Connah's Quay Low Carbon Power

Applicant's Response to Deadline 3 Submissions

Planning Inspectorate Reference: EN010166

Document Reference: EN010166/APP/9.18

Figure 13-1

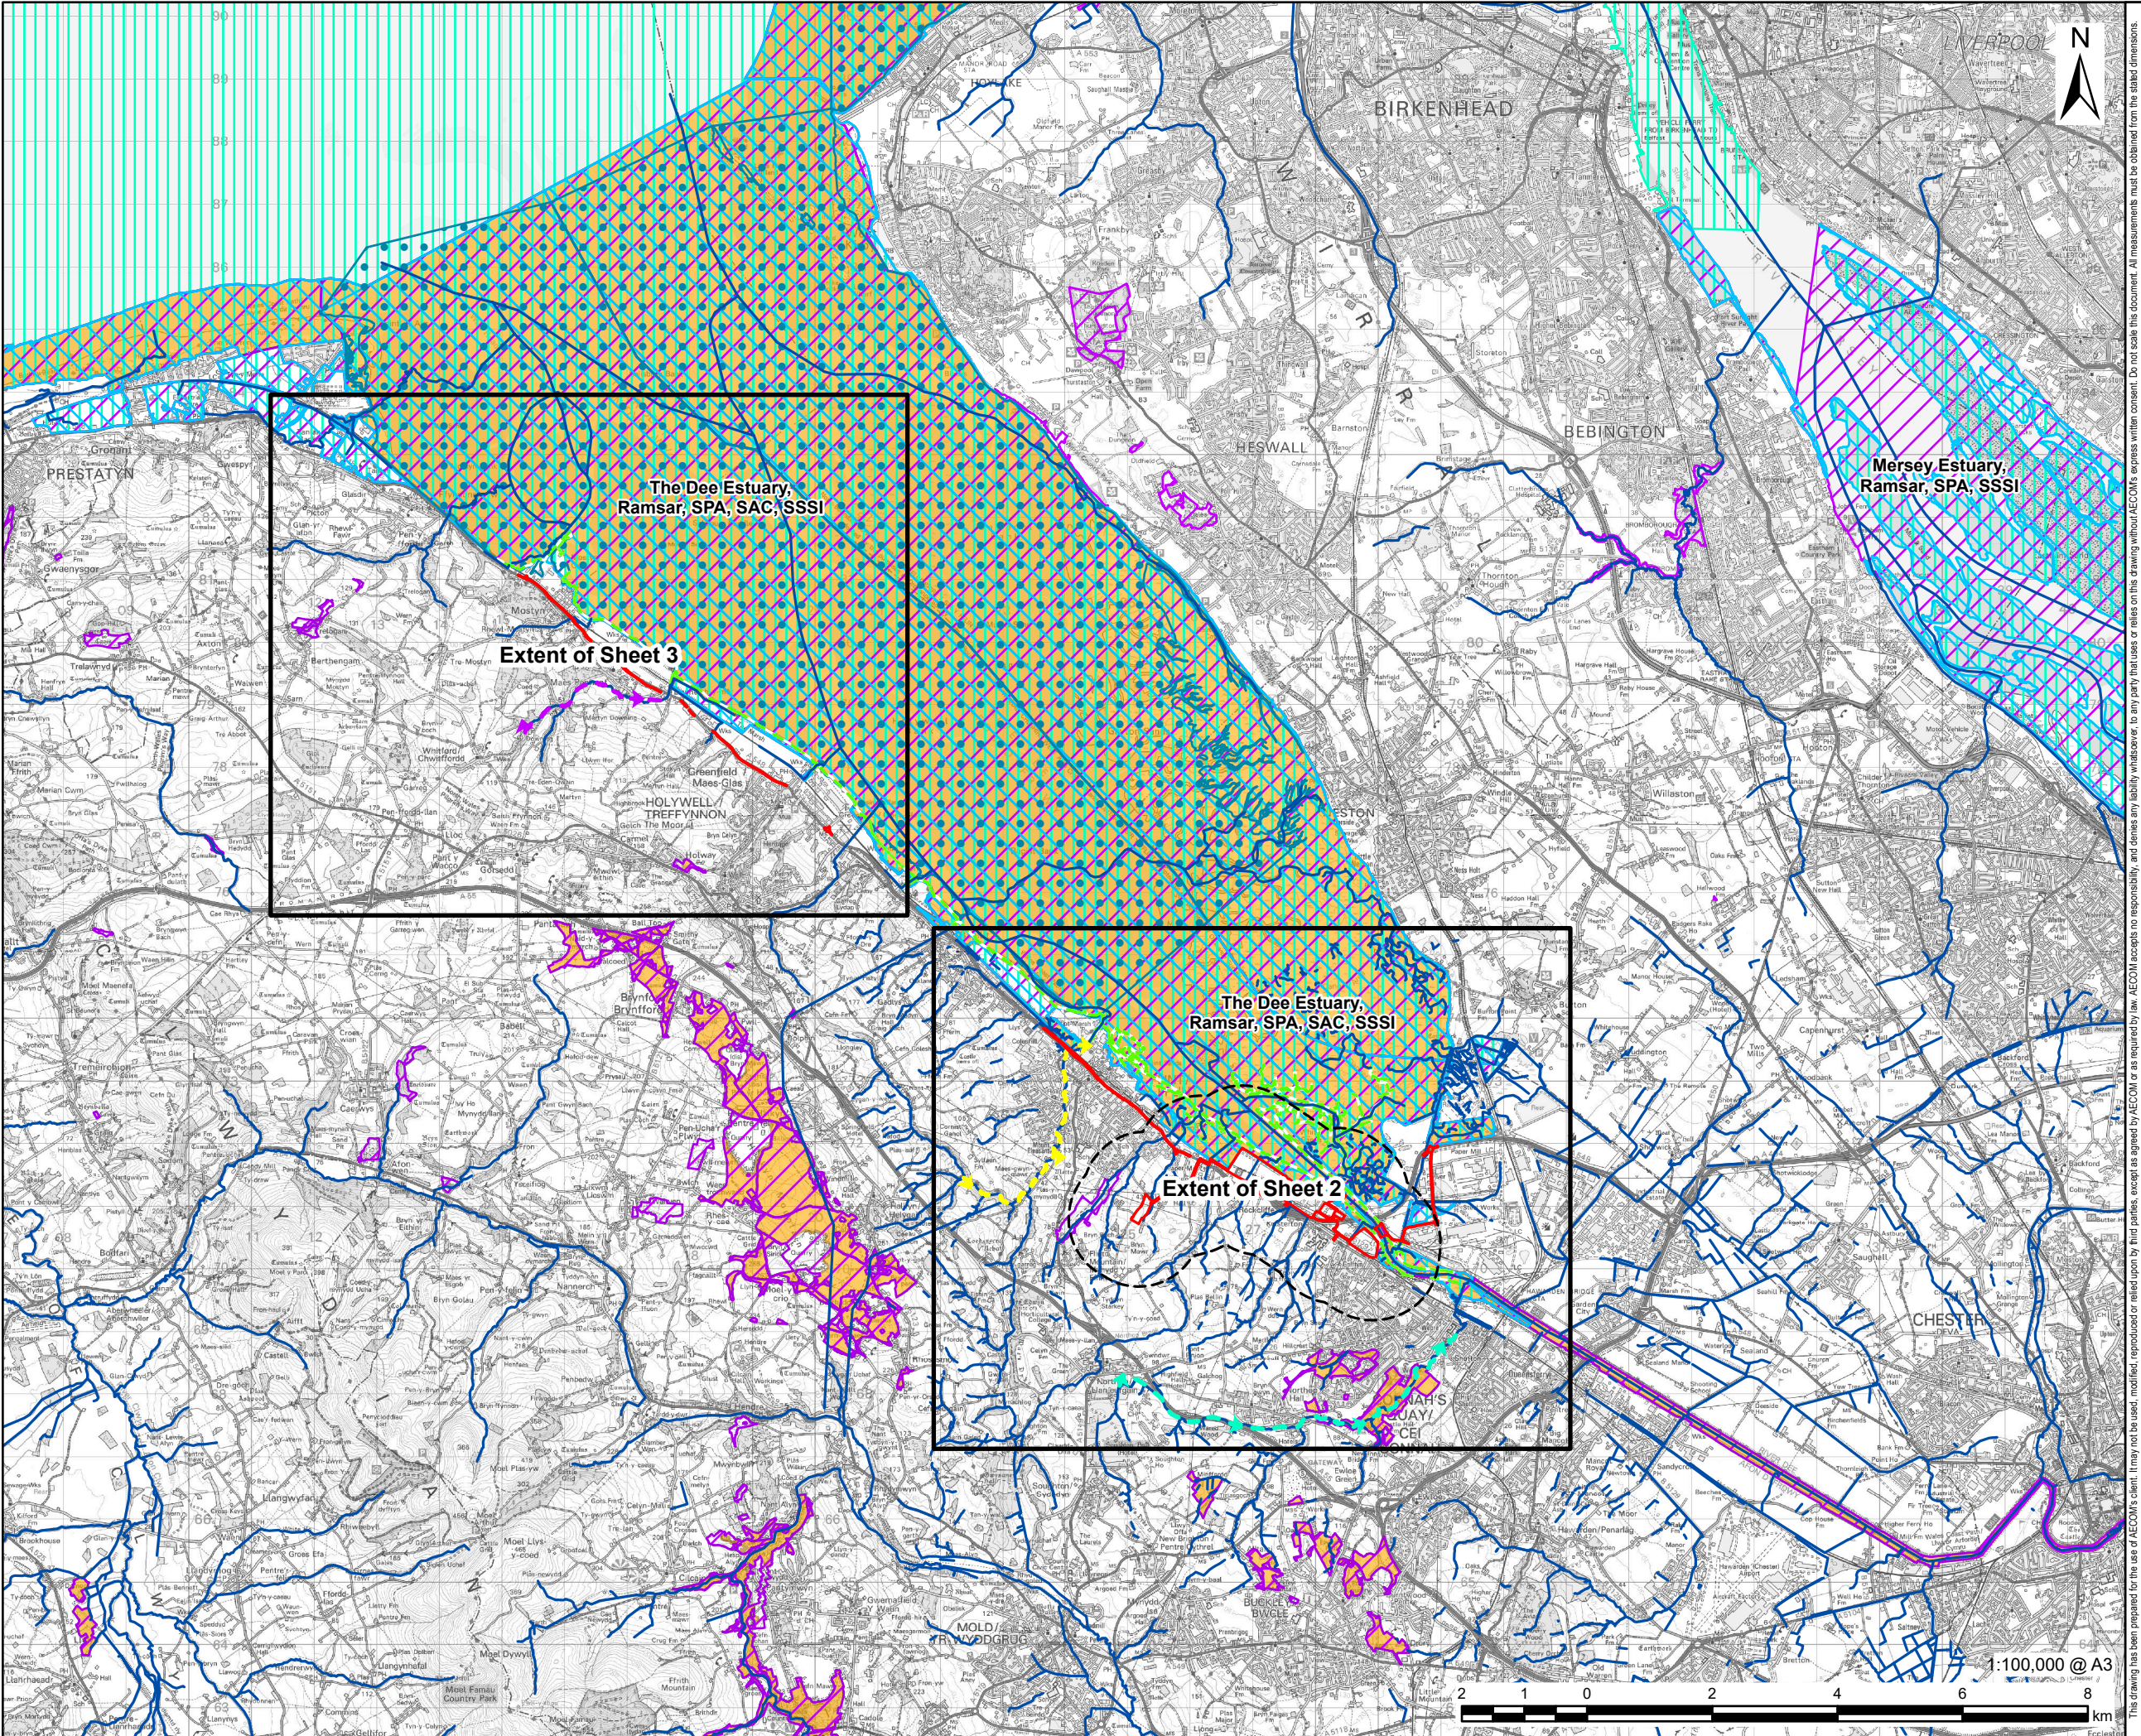
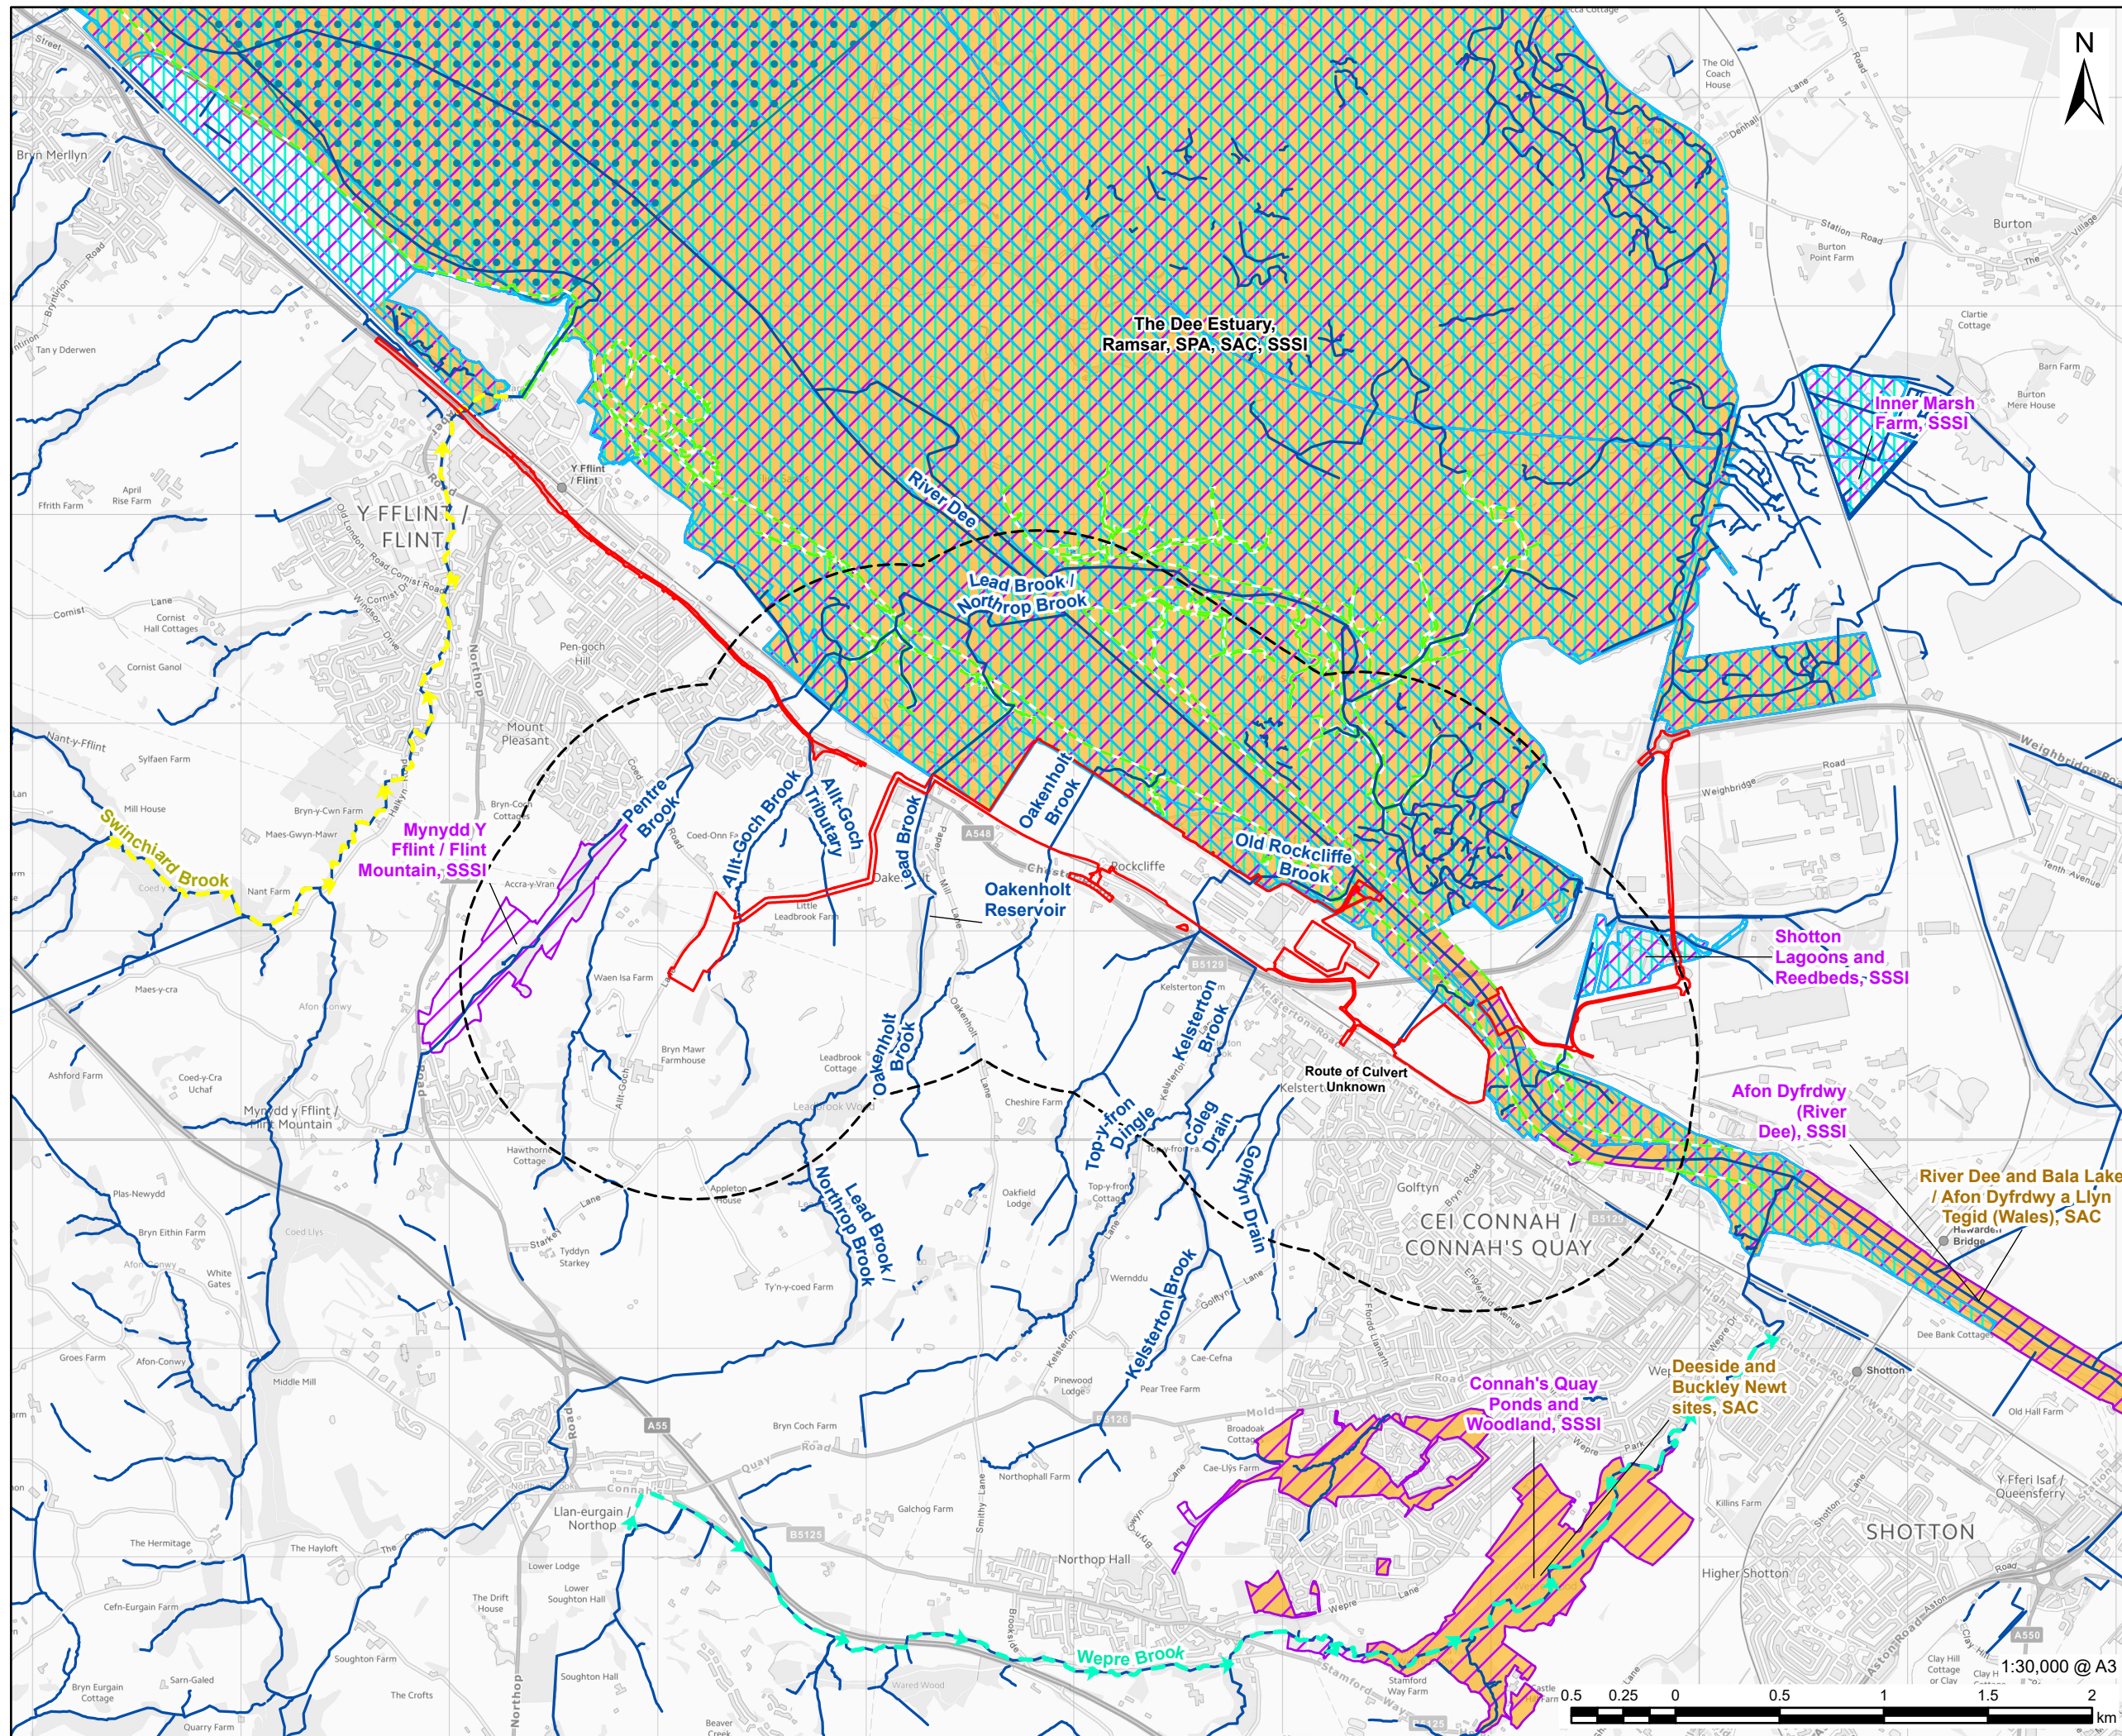
1.36	<p>Question Reference: ExQ1 11.4</p> <p>Examining Authority Question: Flood risk ([APP-051] Ref: Table 13-7 & [APP212] Fig 13C-1) Was joint probability considered in the hydraulic analysis? Where in the tidal modelling has the risk of overtopping of defences from wave action and breach of defences been considered? The appendices state that the MDA is free from flood risk but the Figure 13C 1 appears to contradict this. Why is the site shown in flood zone 3 if the site is actually free from flood risk including future climate change projections? Have the most recent allowances for climate change been included in the flood risk assessment including the uplifts required for flood modelling of critical national infrastructure, such as H++ sea level rise?</p> <p>NRW Response: NRW defers to the Applicant to confirm how they have addressed these matters in their submission. Please also refer to our SoCG with the Applicant (NRW39 – 41). However, regarding</p>	<p>Please refer to the responses provided to ExQ1 Q11.4 in the Applicant's Response to ExQ1 [REP3-059].</p> <p>With regards to wave overtopping, liaison with NRW was undertaken (October 2024) (Appendix 13-F – Hydraulic Modelling Report) [APP-215] which confirmed NRW did not hold any wave data for the site of the wider Dee Estuary. NRW were unaware of historic wave overtopping issues, nor did they hold any historic flood outlines which related to wave overtopping in the site location. They therefore felt it unlikely that wave overtopping is a significant risk at the site.</p>

Source Document	Reference	Source Document Issue / Theme	Applicant's Response
		<p>consideration of a breach in defences for the tidal modelling, this was subject to previous discussions and agreement between the Applicant and NRW. There are no NRW maintained flood risk management defences alongside the Main Development Area and therefore it is considered that the modelling approach (undefended scenario) will provide conservative estimates of flood levels/risk.</p> <p>Regarding the site's susceptibility to flood risk, the Flood Map for Planning at the location of the site is based on broad-scale fluvial and tidal modelling. As part of the submitted Flood Consequences Assessment, the Applicant has taken a copy of NRW's most up-to-date hydraulic model for this location and updated this to provide a more detailed representation of risk to the site, following preapplication engagement between NRW and the Applicant. This is documented in the Hydraulic Modelling Report. Further advice on the details of the modelling should be sought from the Applicant.</p> <p>For the H++ scenario, Section 7 of the Welsh Government's current Climate Change Allowance guidance "Flood Consequences Assessments: Climate change" states that "You should contact the Local Planning Authority to establish whether an assessment of the H++ scenario is required as part of a flood consequences assessment." We therefore direct the ExA to FCC for any further advice regarding this matter.</p>	<p>With regards to the H++ scenario the Flood Consequences Assessments: Climate change guidance (2021)¹ recommends the H++ scenario is more often used for infrastructure with a longer design life beyond the end of the century and / or is particularly sensitive to flooding. The Proposed Development has a design life of 30 years, and it was shown in Figure 13F-20: Tidal Maximum Extents (70th Percentile Events) in Appendix 13-F: Hydraulic Modelling Report [APP-215] to be no flooding within the operational footprint during the design flood event.</p> <p>Within the Statement of Common Ground with Flintshire County Council [APP-280] the assessment methodology for the Flood Consequence Assessment was agreed between the parties to be appropriate / acceptable.</p> <p>Within Table 12 of the Applicant's Response to Local Impact Report [REP3-058] it is noted that FCC would defer to comments from NRW, as the statutory body for coastal and fluvial flood risk, on matters relating to flooding.</p>
